Consultation Response from KC, Lead Local Flood Authority		
2021/91638 Land at Hart Street, Newsome, Huddersfield, HD4 6LS		
Reserved matters application pursuant to outline application no.2016/91479 (appeal no. APP/Z4718/W/17/3173711) for erection of 22 dwellings		
Date Responded: 7th June 2021	Responding Officer: Paul Farndale	Responding Ref:

Kirklees Flood Management & Drainage acting as LLFA, statutory consultees for surface water, OBJECT to this application on the grounds that there is no demonstration within the layout design that 'space has been made for water'.

PLANNING
DRAWING

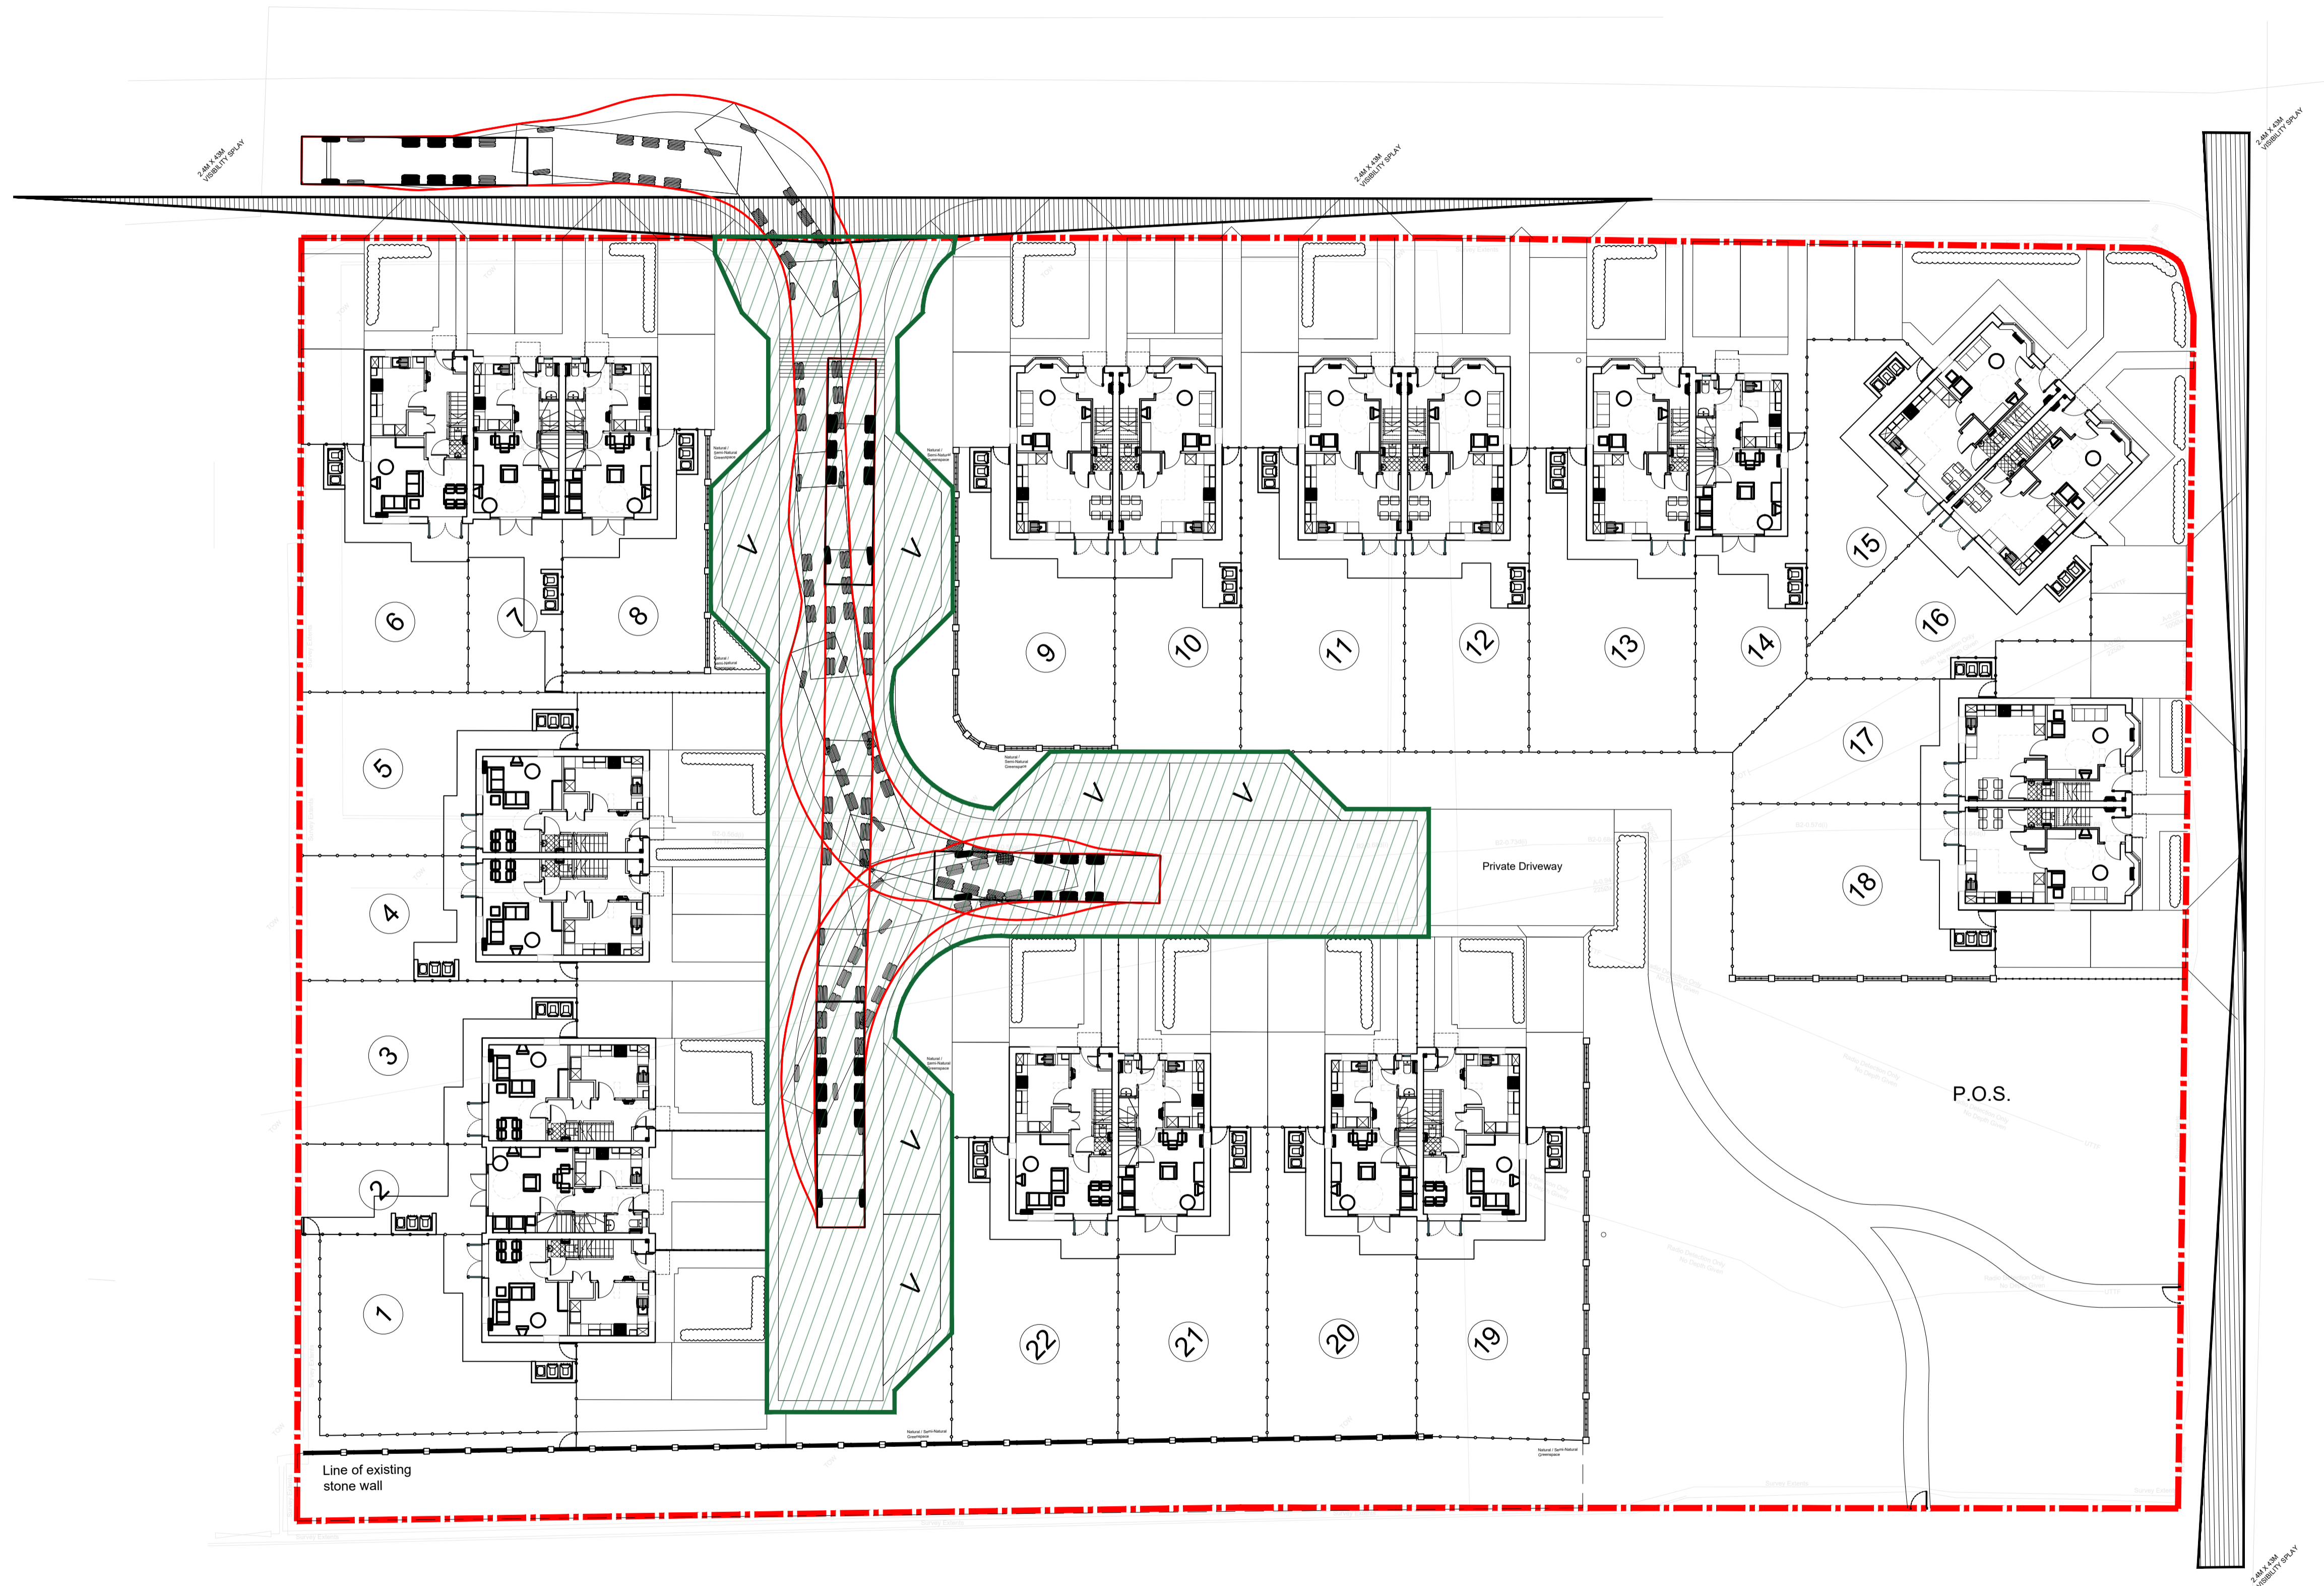
The layout will need to accommodate diversion of the watercourse through the site and connect back into public sewer. Although not submitted with the application we are satisfied that work has been completed proving that the watercourse via ponds connected into the public combined sewer.

The layout will need to accommodate separate foul and surface water systems. The latter will include attenuation requirements. We believe that the area of the ponds should be taken into account as previous direct discharge, of which a 30% improvement on peak flows should be achieved in accordance with Kirklees' Local Plan Policy.

Flood routing from catchment and site exceedance and blockage events should avoid curtilage where reasonably practicable.

None of the above has been demonstrated to conclude that a safe layout has been designed around these constraints.
